CITY OF ALBUQUERQUE

April 19, 2022

**Re: MAS Charter School
Neighborhood Impact Assessment, HT#L16D037**
Report dated April 2022
Engineer's Stamp -----

The subject Neighborhood Impact Assessment (NIA) received April 5, 2022, has been reviewed by the City of Albuquerque Planning Development Transportation Section. The City has the following comments that should be addressed in the next submittal.

Figure 1. Site Plan

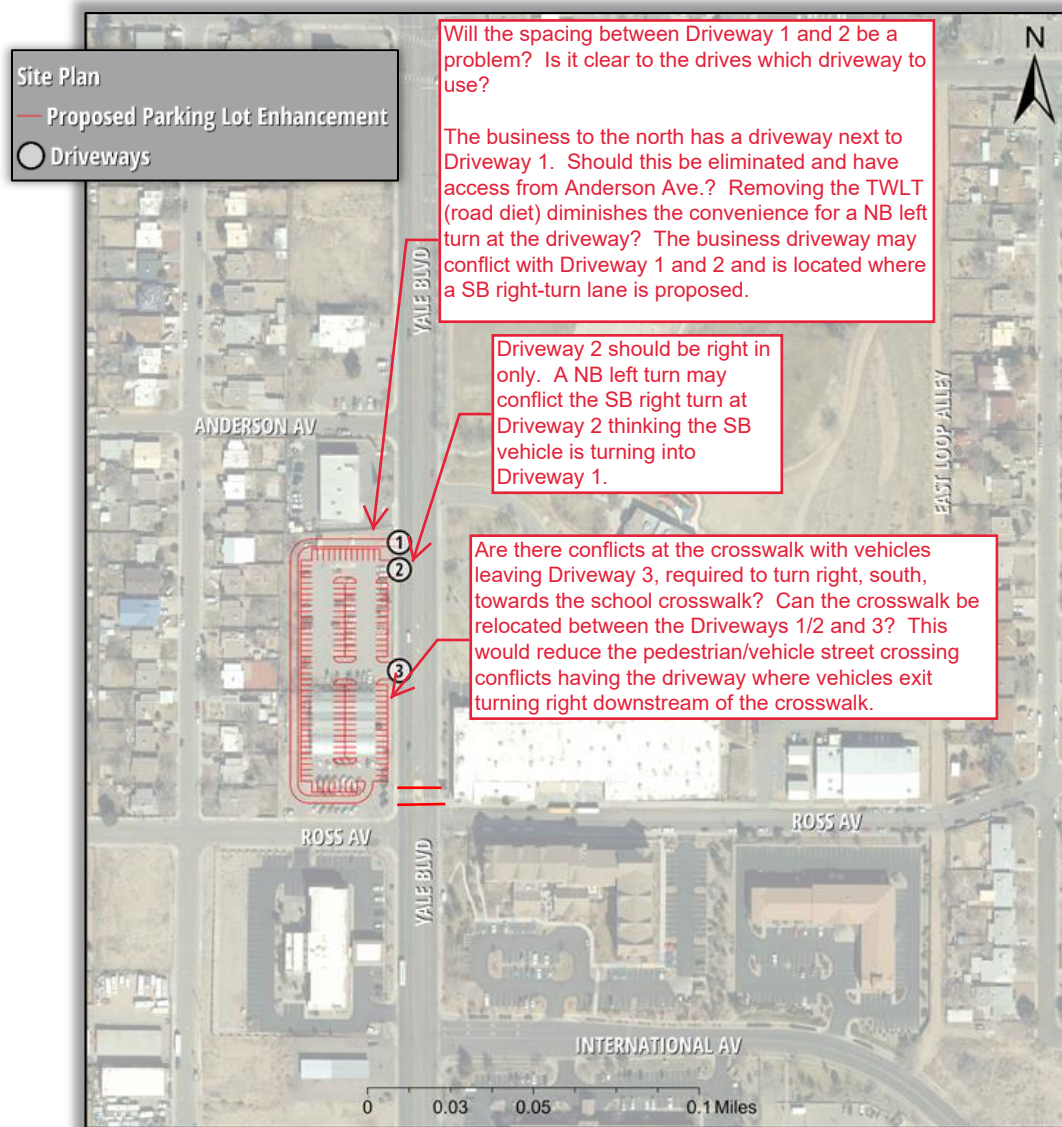
- Will the spacing between Driveway 1 and 2 be a problem? Is it clear to the drivers which driveway to use? Are these areas in the proposed parking lot segregated? Is it possible to correct after entering the wrong driveway; drivers that wish to park can access the parking area or vehicle dropping off can access the queue?

- The business to the north has a driveway next to Driveway 1. Should the business driveway be eliminated and have access from Anderson Ave.? Removing the TWLT (road diet) diminishes the convenience for a NB left turn at the business driveway? The business driveway may conflict with Driveway 1 and 2 and is located within a proposed SB right-turn lane.

- Driveway 2 should be right in only. A NB left turn may conflict the SB right turn at Driveway 2 thinking the SB vehicle is turning into Driveway 1.
- Provide a cross-section and plan view of the proposed Road-diet configuration. Bike lanes are proposed on Yale Blvd, see MRCOG Long Range Bikeway system mapping.

Figure 9: South Loop Build-out Traffic Volumes

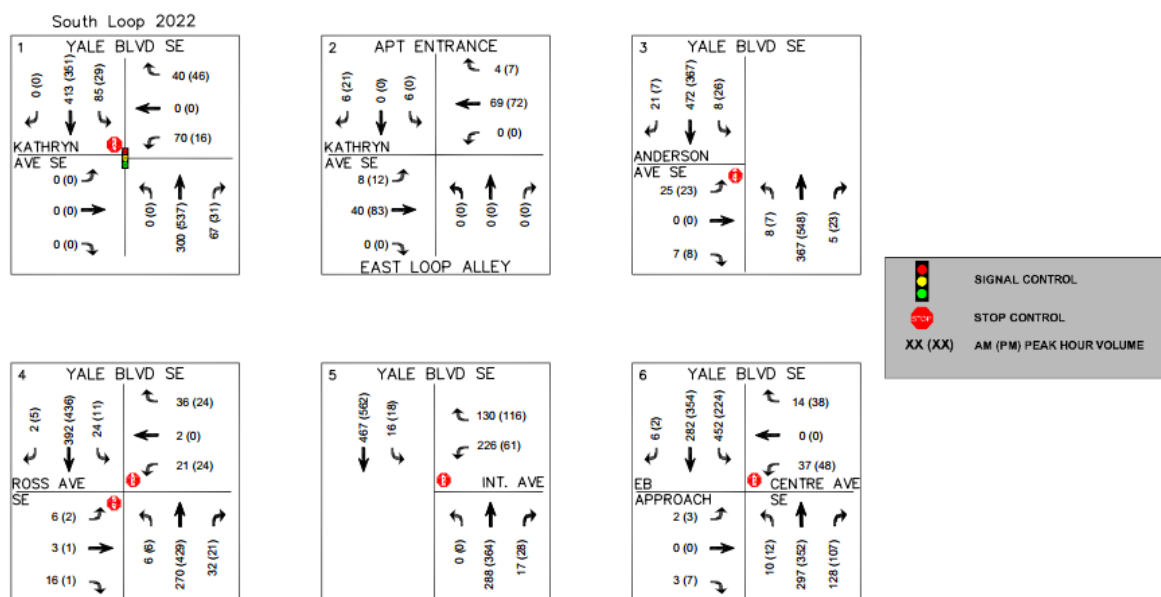
- Ross Ave. is proposed as a Bike route, was this considered in the NIA?
- Table 24: Queuing Analysis, South Loop Build-out; Label the columns. The available queue storage is deficient (1460' max required, 1400' available) The sentence following Table 24 says the storage is sufficient, is that correct?
